WEST SUSSEX COUNTY COUNCIL CONSULTATION

TO:	Arun District Council FAO: Simon Davis
FROM:	WSCC - Highways Authority
DATE:	6 November 2019
LOCATION:	77 Aldwick Road, Bognor Regis, PO21 2NW
SUBJECT:	BR/233/19/PL Part change of use of ground floor & formation of a first floor rear extension to create 2 No self-contained studio flats with associated refuse/recycling & cycle store (resubmission following BR/63/18/PL).
DATE OF SITE VISIT:	N/A
RECOMMENDATION:	Advice
S106 CONTRIBUTION TOTAL:	N/A

Drawing
EXISTING & PROPOSED
CYCLE & BIN STORES

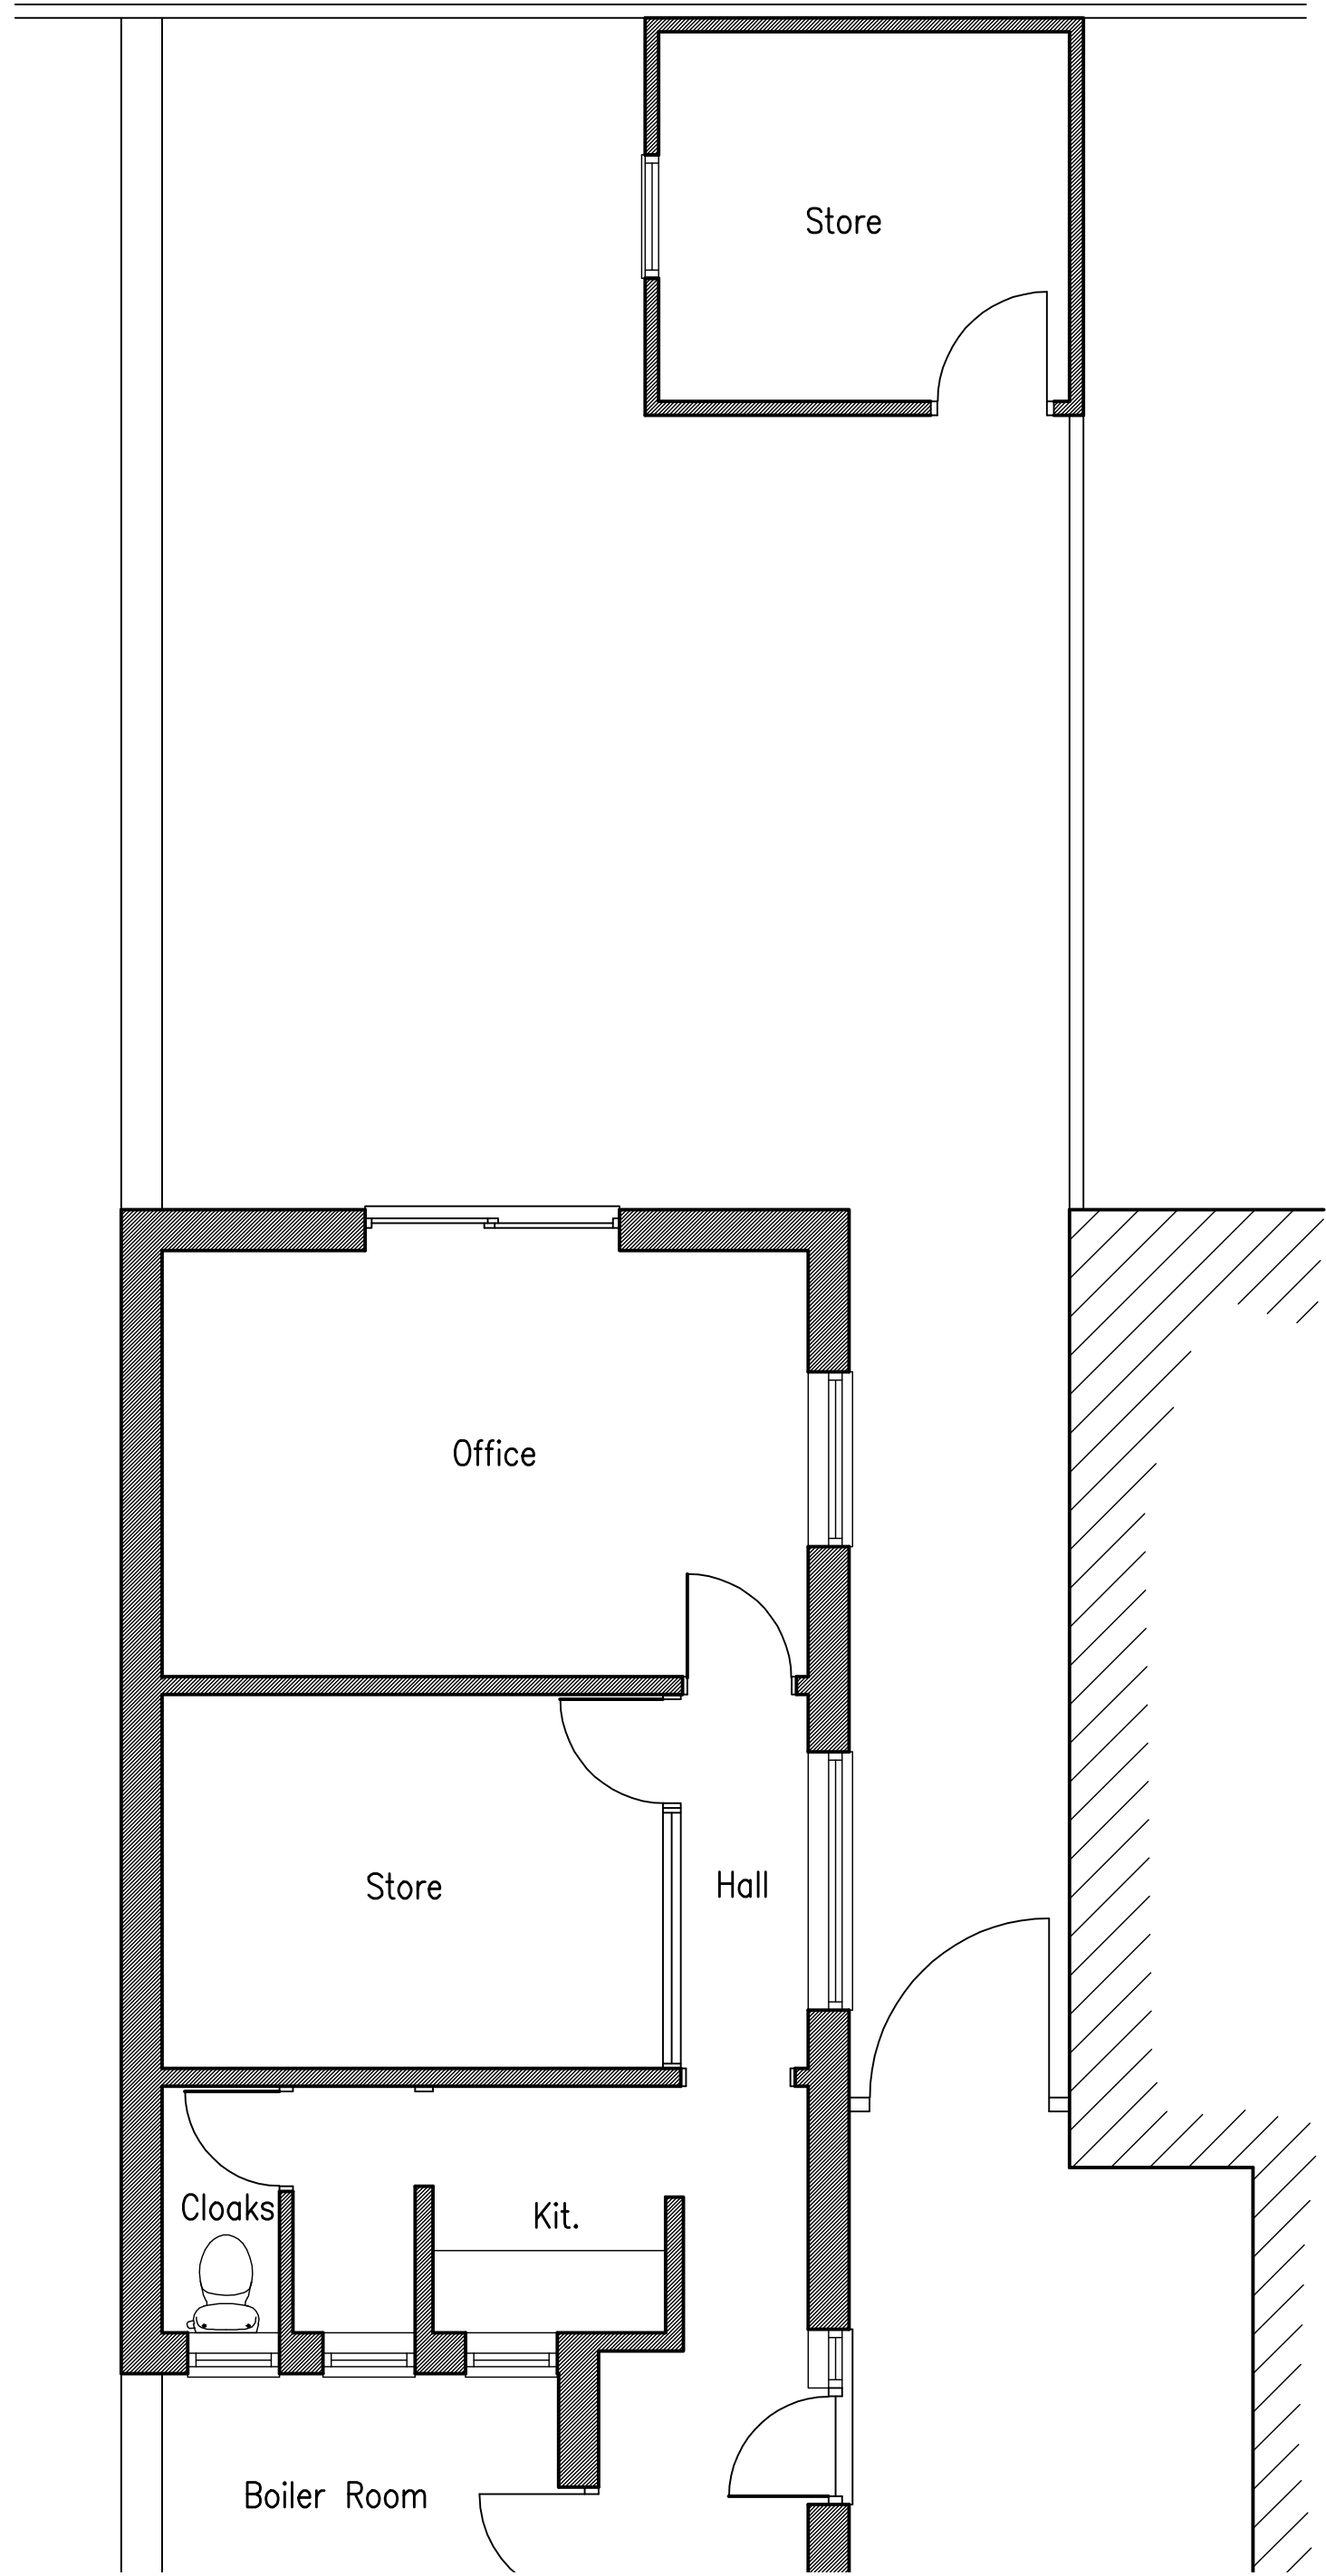
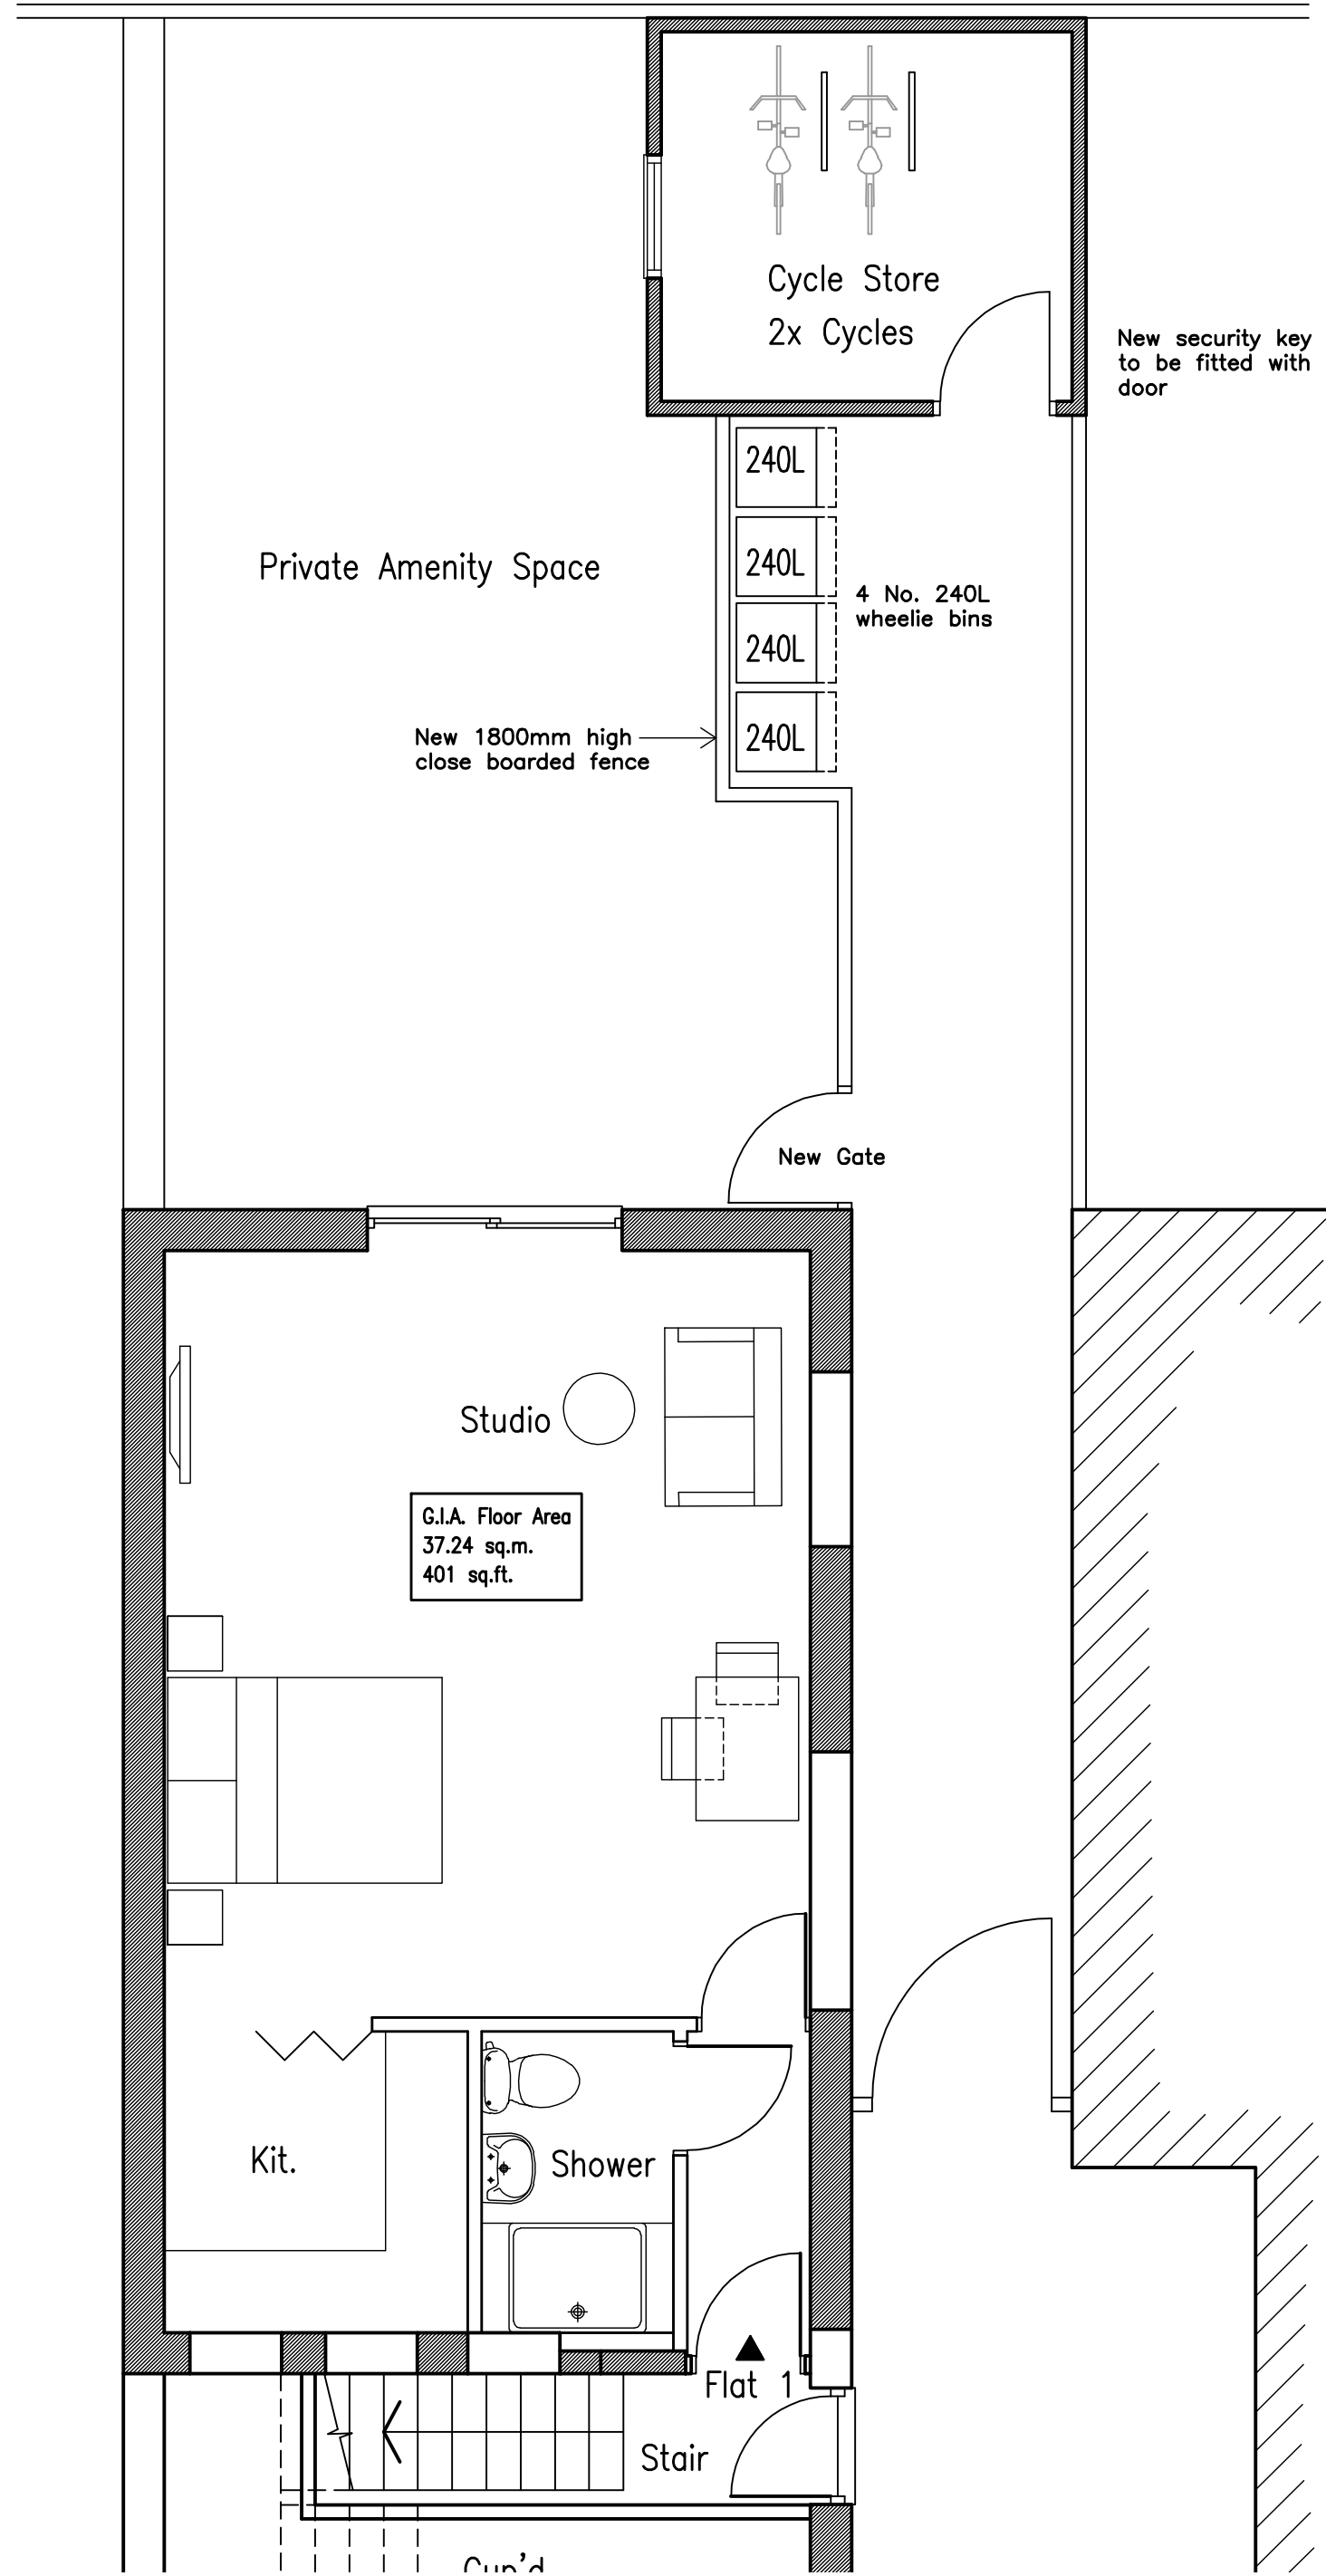
Secure and covered cycle parking for at least 2 cycles has been demonstrated in the plans. Under WSCC parking standards, 1 cycle space should be provided for dwellings with 1-2 bedrooms. Therefore the proposed cycle parking provision is in accordance with WSCC parking standards. The inclusion of cycle parking helps promote the use of sustainable alternative modes of transport to the private car.

No part of the development shall be first occupied until covered and secure cycle parking spaces have been provided in accordance with plans and details submitted to and approved by the Local Planning Authority.
